Our Ref: FP/137/20/DOC

Approval of details reserved by condition imposed under ref FP/171/18/PL relating to Condition Nos 21 - waste/recycling storage and 22 - external lighting.

Land On West Side Of Stanhorn Grove Felpham PO22 8FS

Condition Number 21

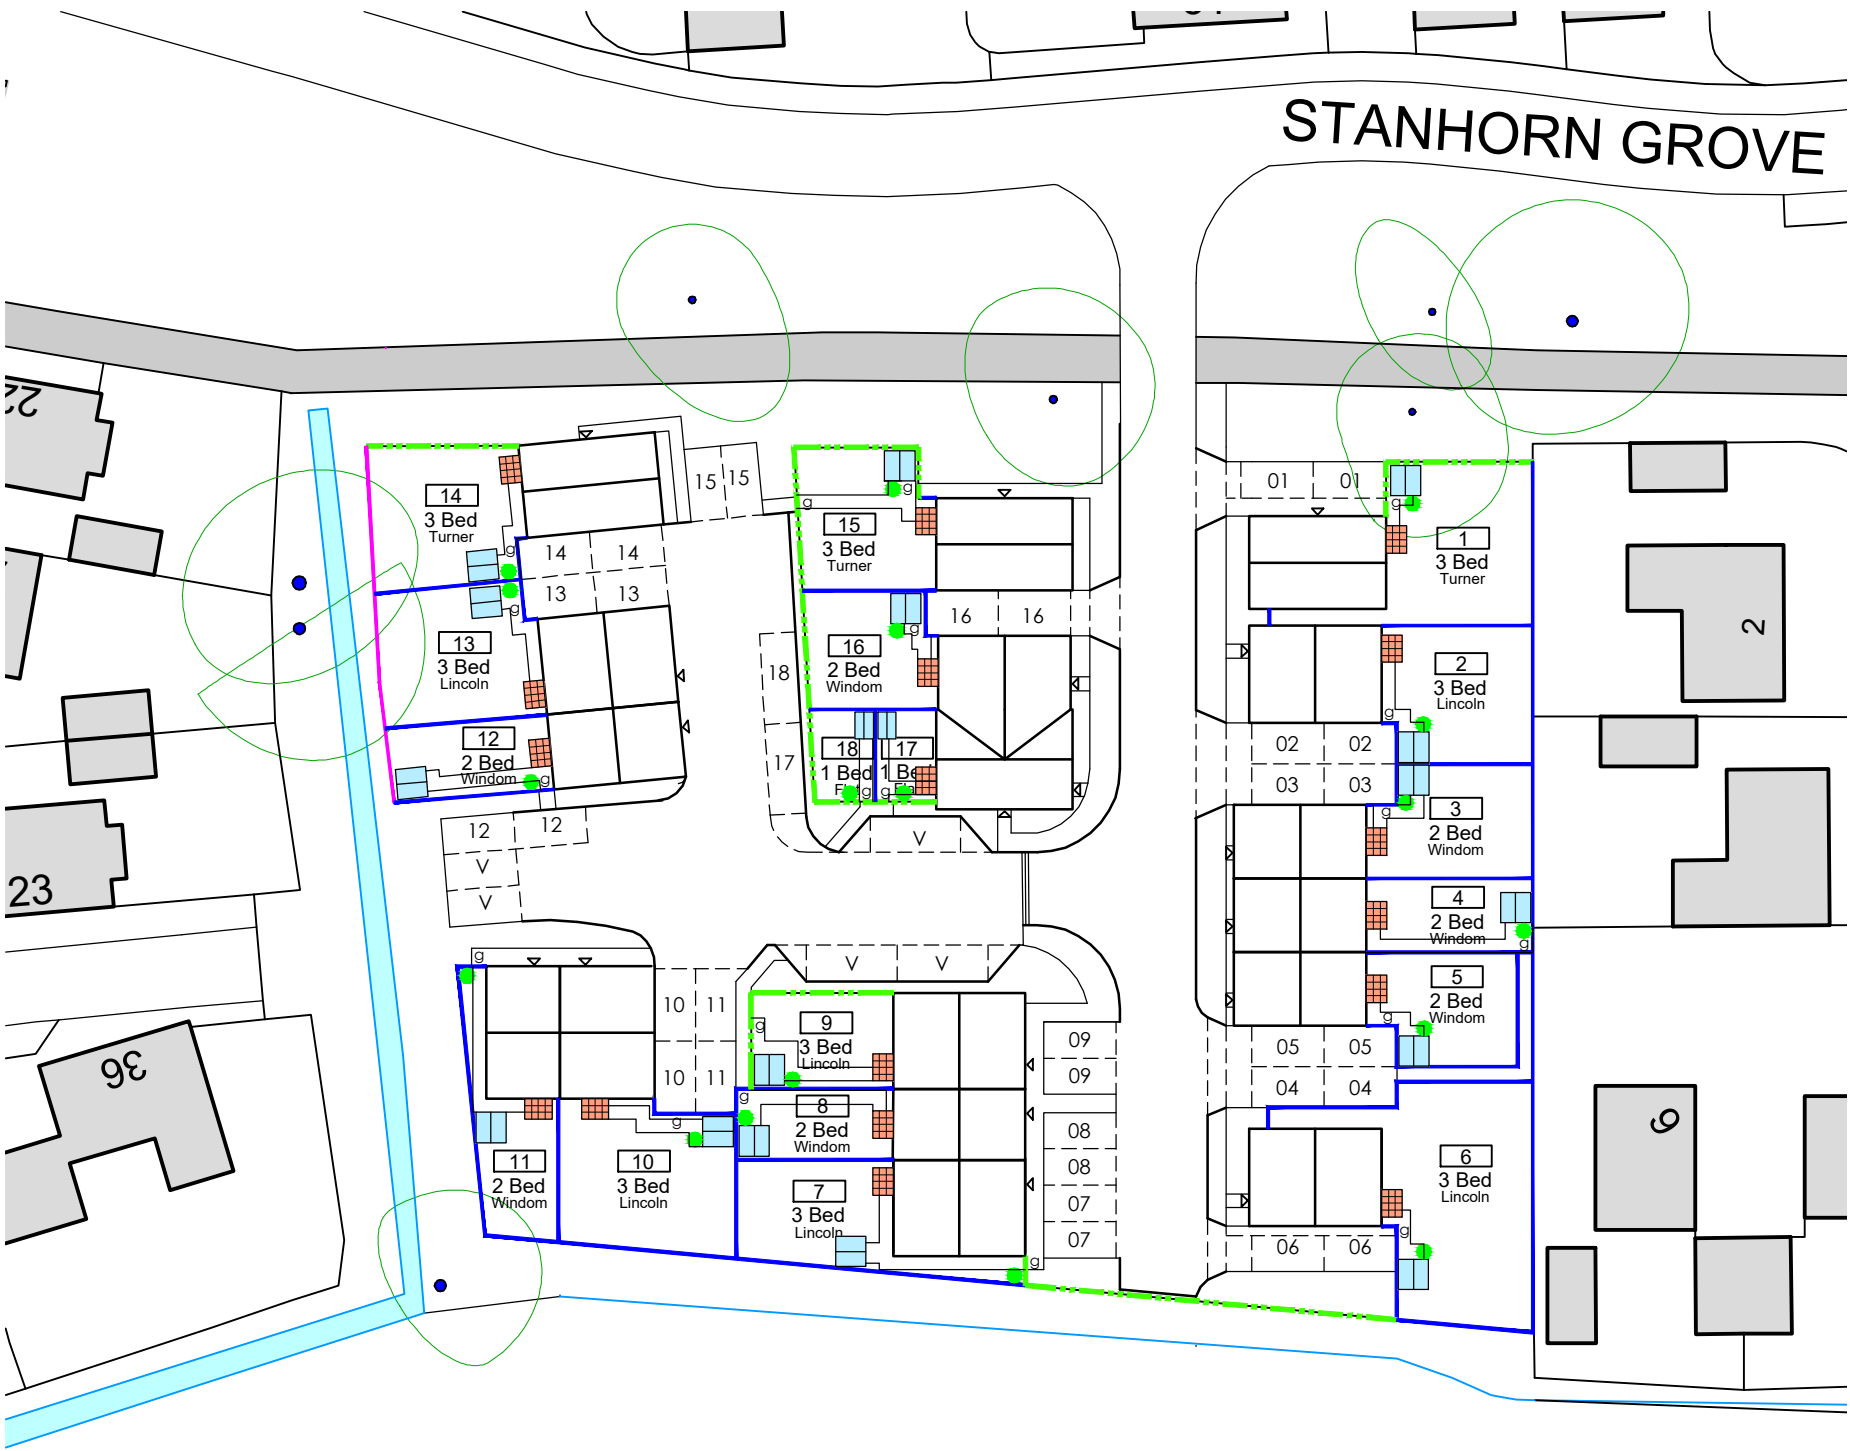
The submitted details in respect of bin storage namely the use of hardstanding spaces within the curtilage of the houses with bin collection points on the highway as detailed on drawings PL-2-08 Rev D "Site Layout - Parking/Cycles/Bins" and PL-2-50 Rev A "External Works" is considered to provide an acceptable scheme and satisfies the requirements of the condition.

The condition is therefore fully discharged insofar as the submission of details relates and, on the understanding, that the hardstanding bin storage spaces will be permanently retained in a condition that is fit for purpose.
